Chamisa Cove Subdivision Sidewalk Culvert Revision

City Project # 656081

Re: Chamisa Cove Subdivision Drainage Report

Engineer's Stamp dated 8-18-00 (H11/D61)

CITY OF ALBUQUERQUE PUBLIC WORKS DEPARTMENT ENGINEERING GROUP			
CHAMISA COVE GRADING & DRAINAGE PLAN			
Design Review Committee	City Engineer Approval	Last Design Update	Mo./Day/Yr.
City Project No.	Zone Map No.	Sheet	Of
		H11/D61	H-11-7

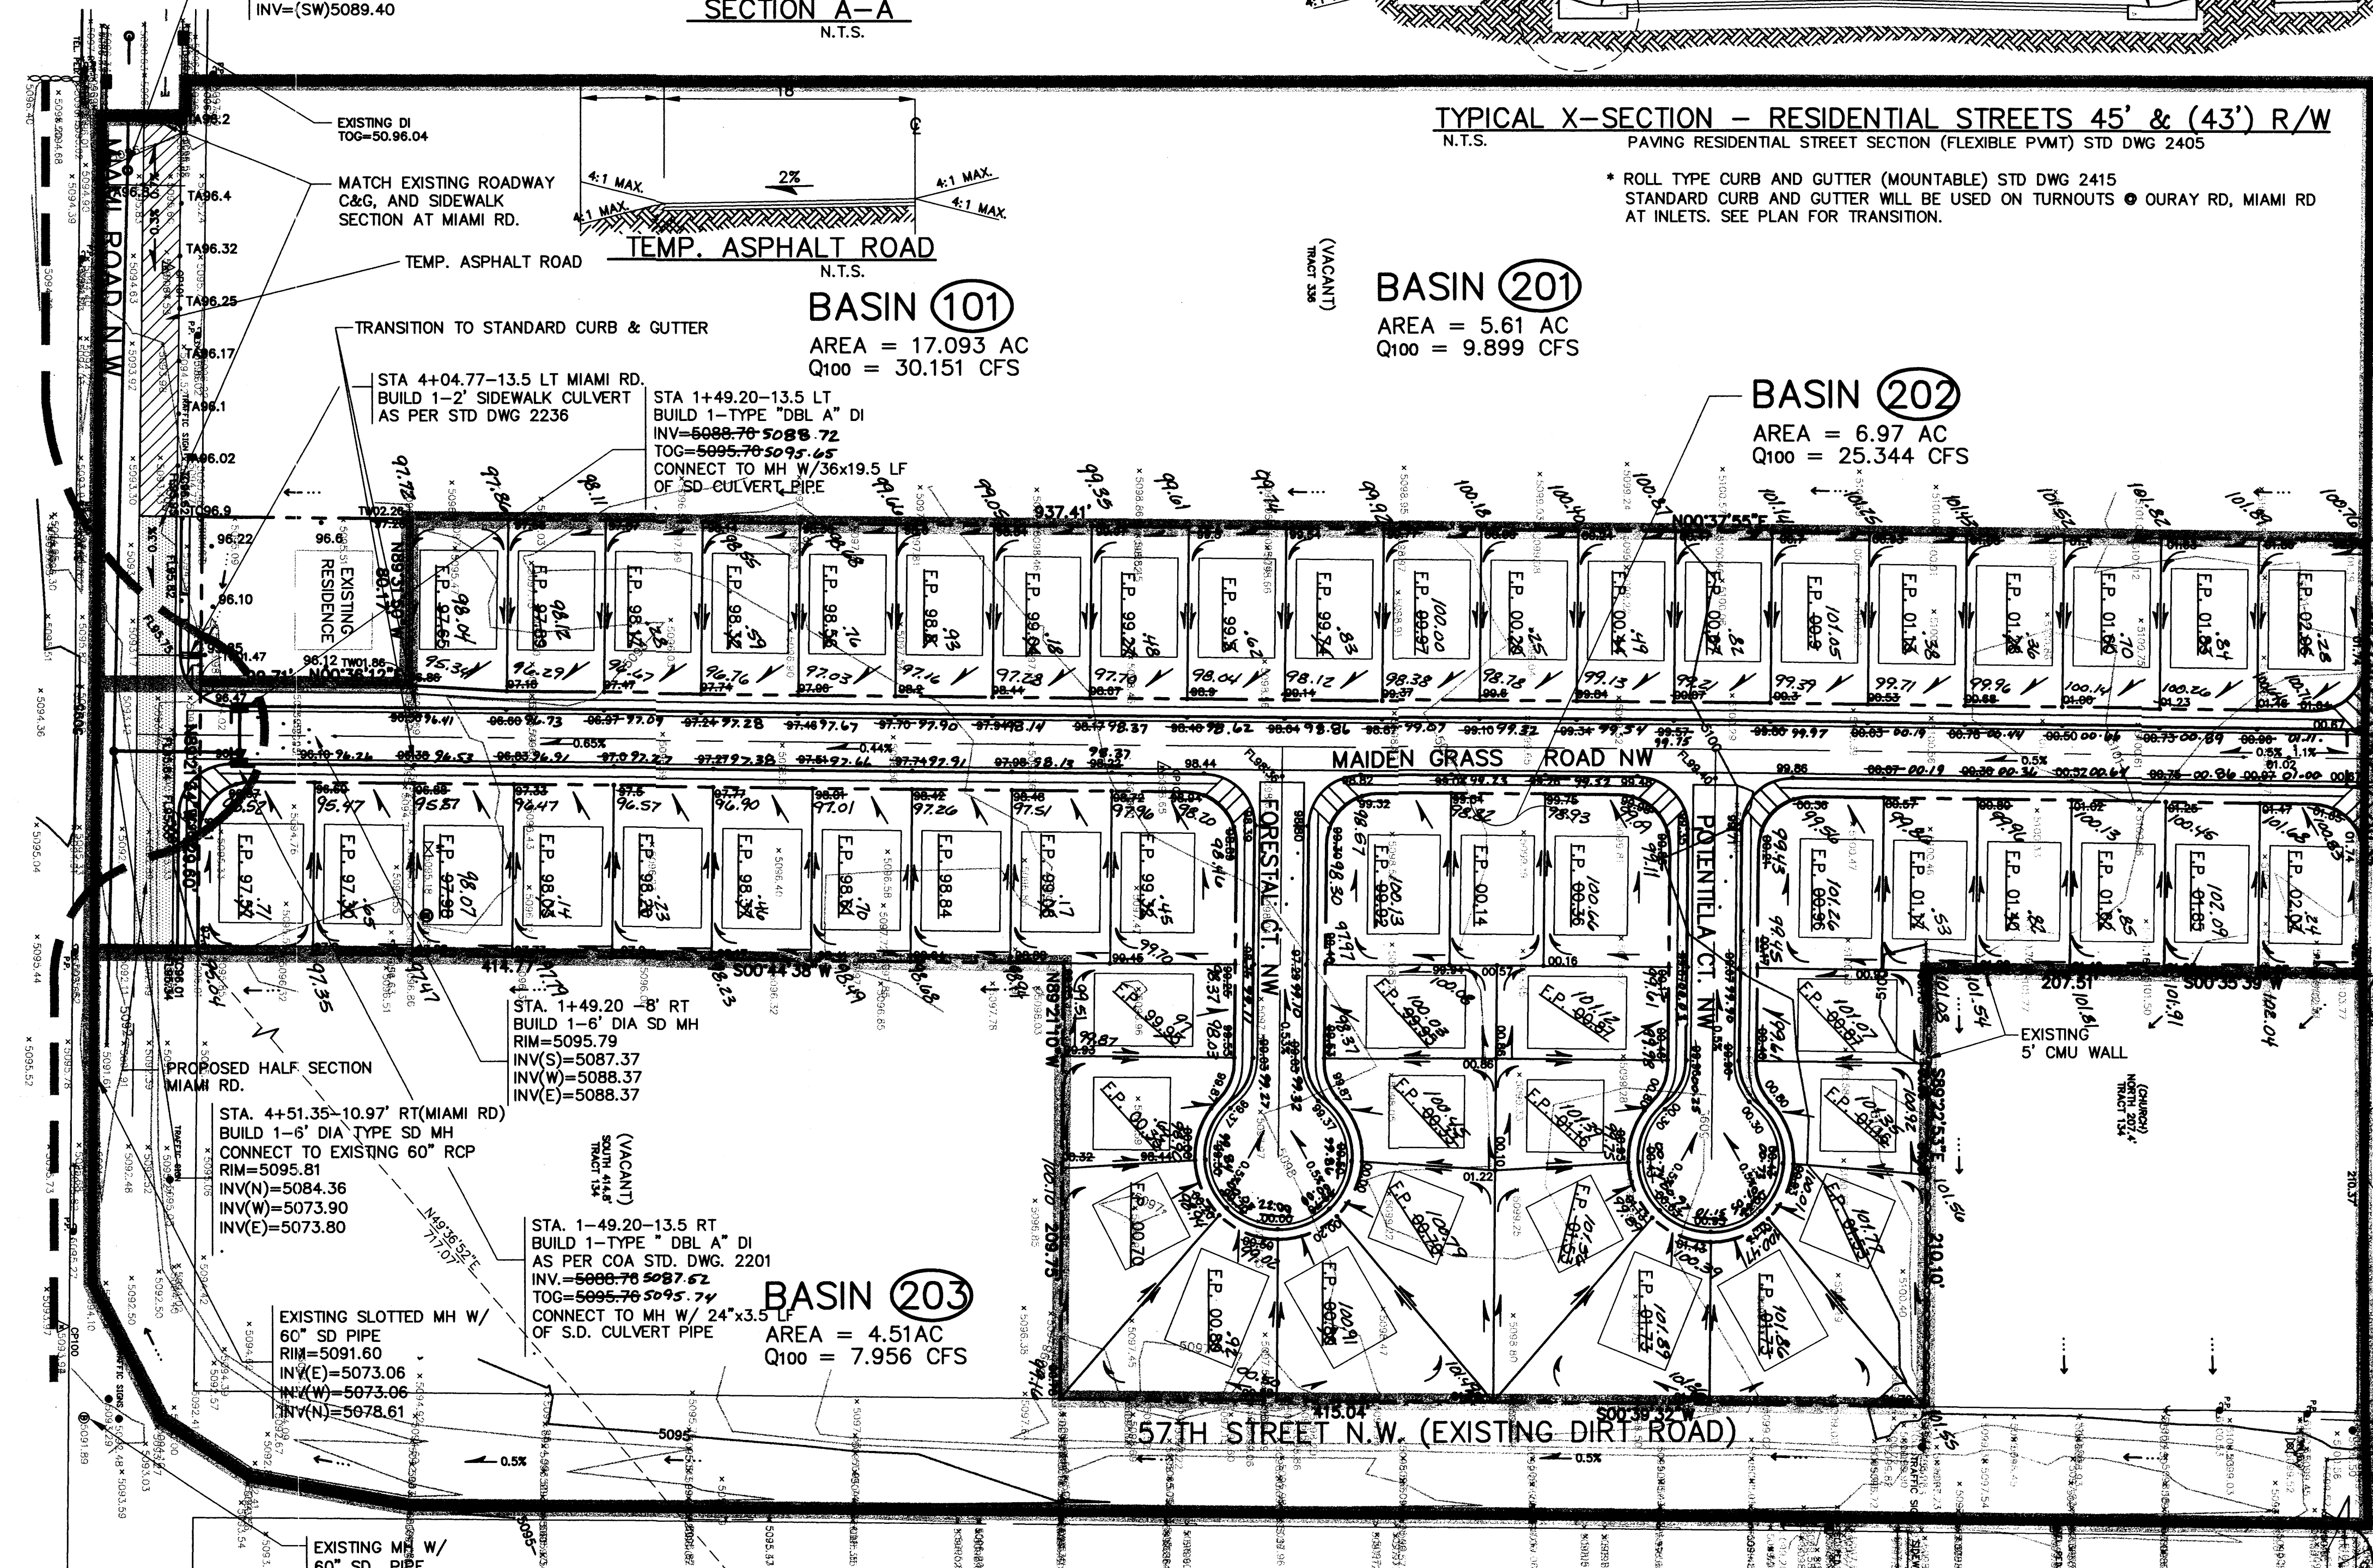
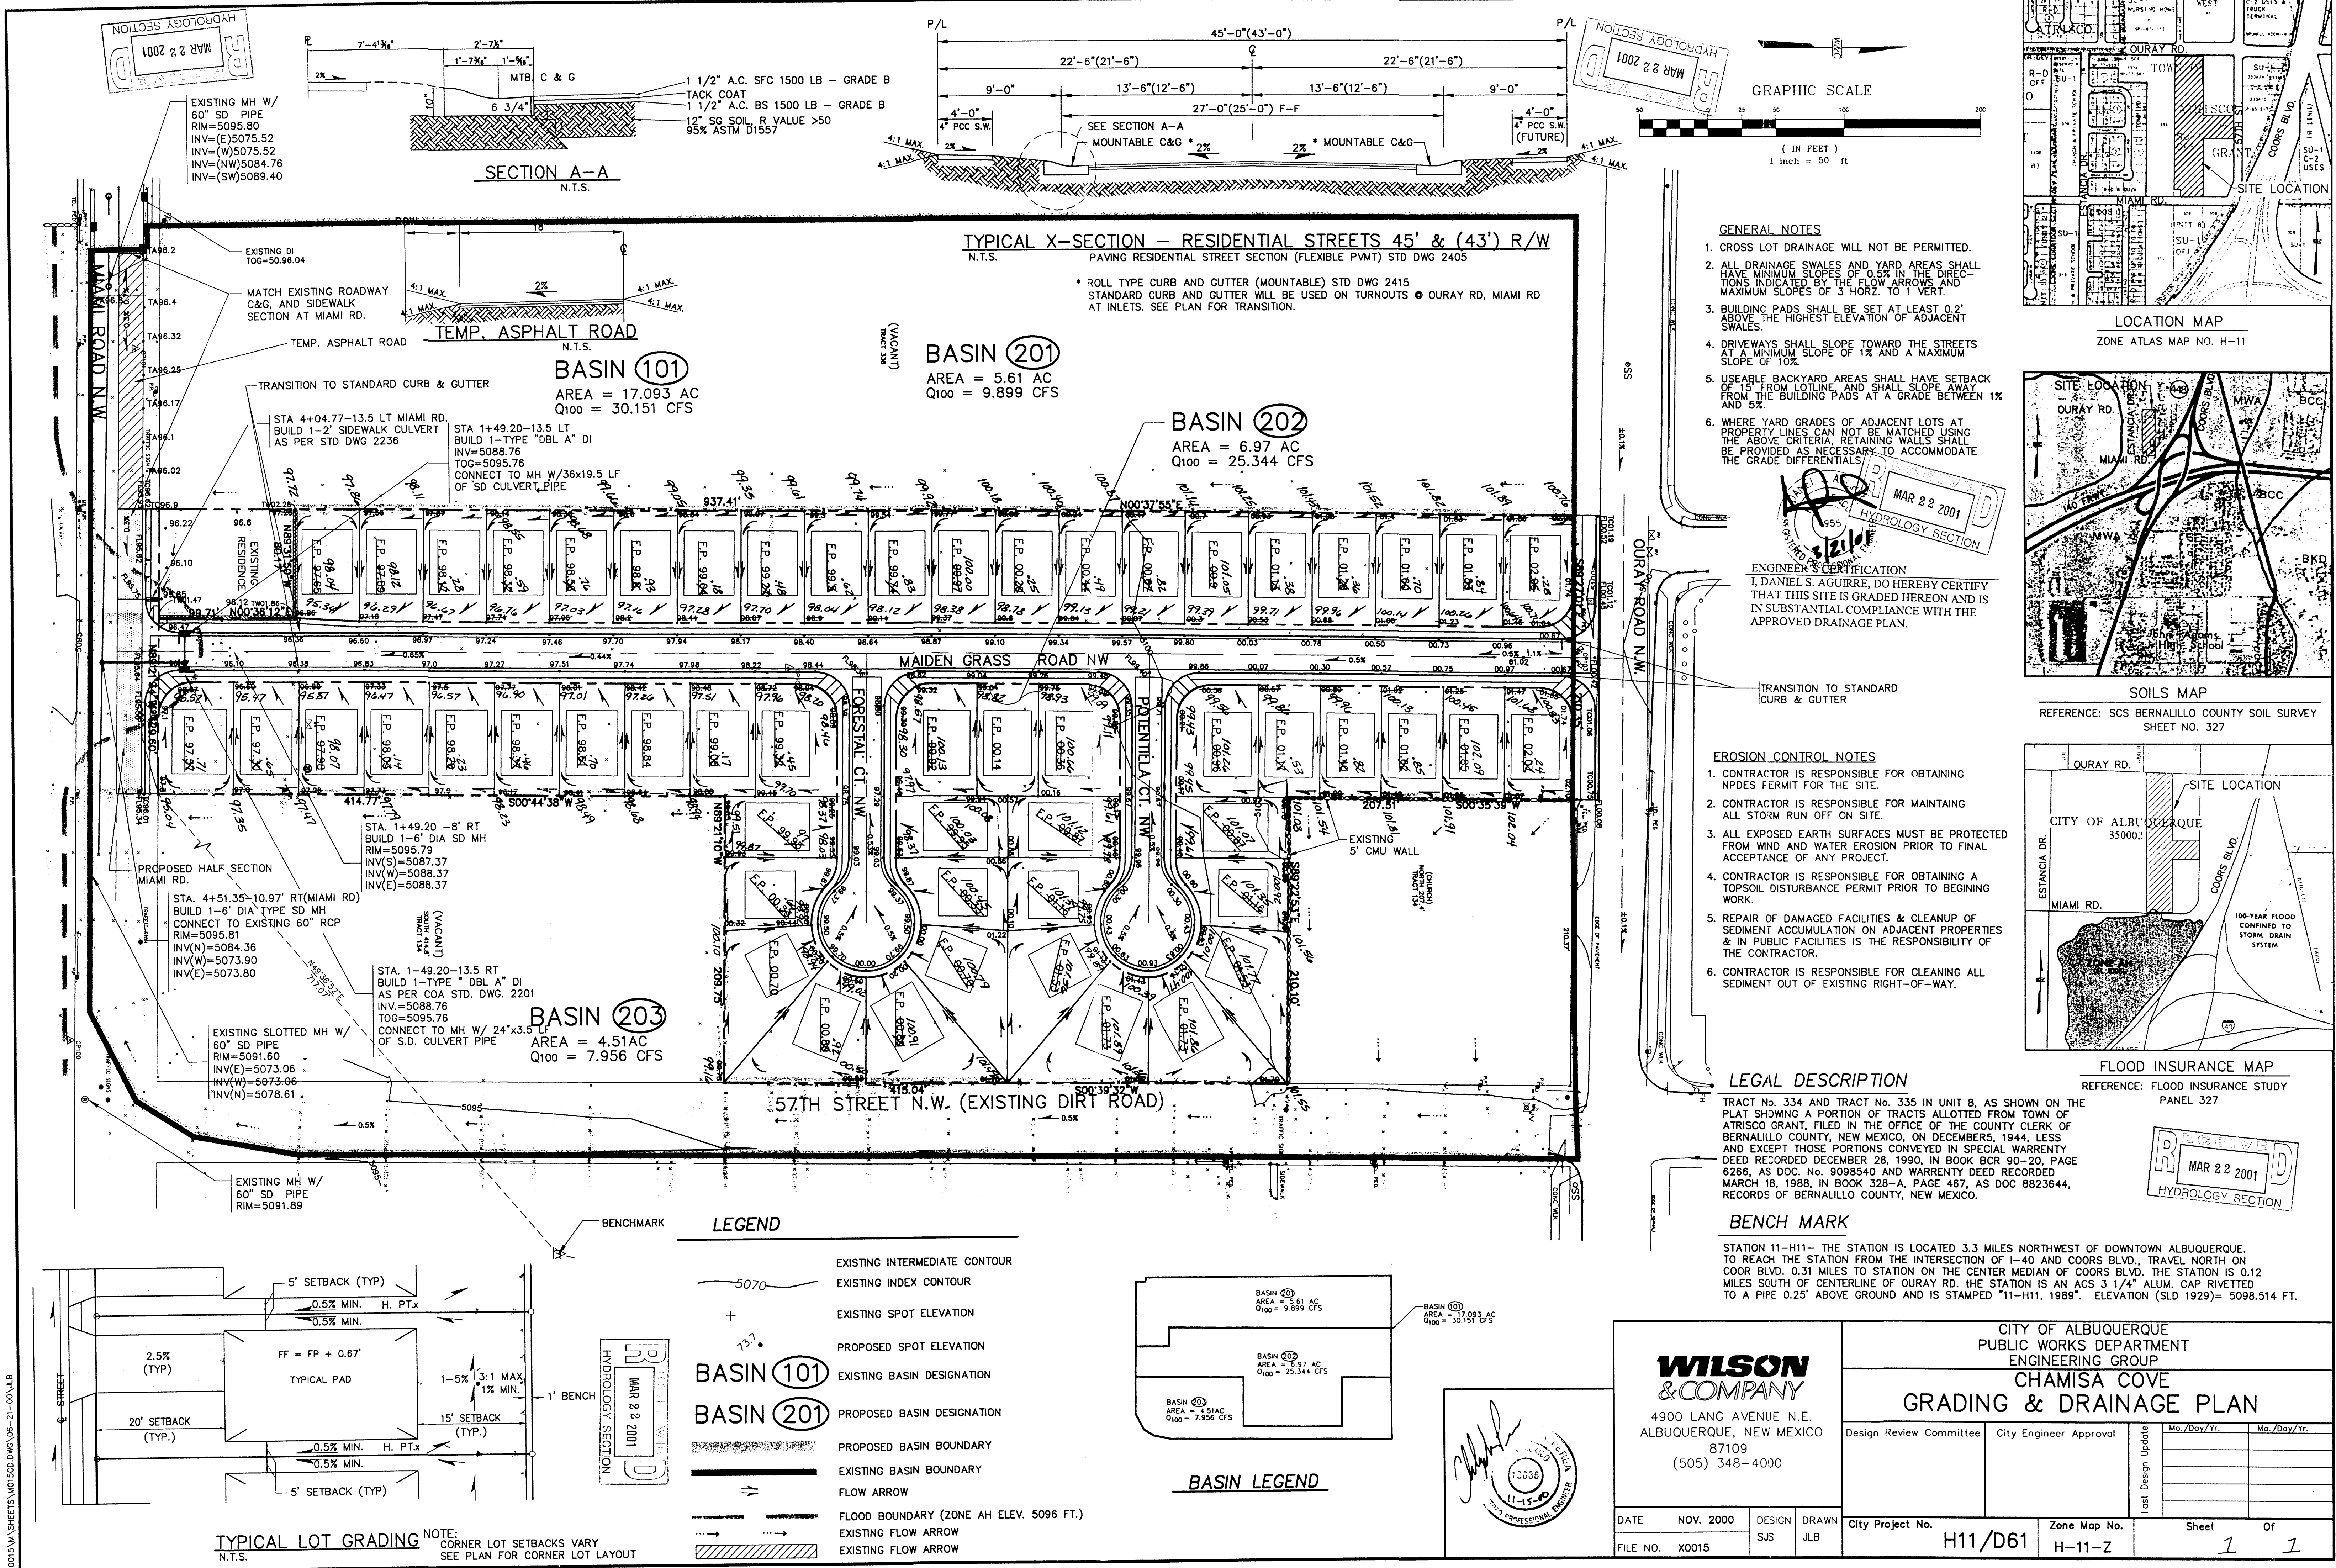
The intension of the sidewalk culvert was to surface drain the runoff from Tract A onto Miami Road. Due to an elevation difference from Miami Rd. and Tract A we plan to eliminate the sidewalk culvert and replace it with a French drain system located on the southeast end of Tract A (see Figure A). The proposed French drain will be sufficient for the runoff generated by Tract A.
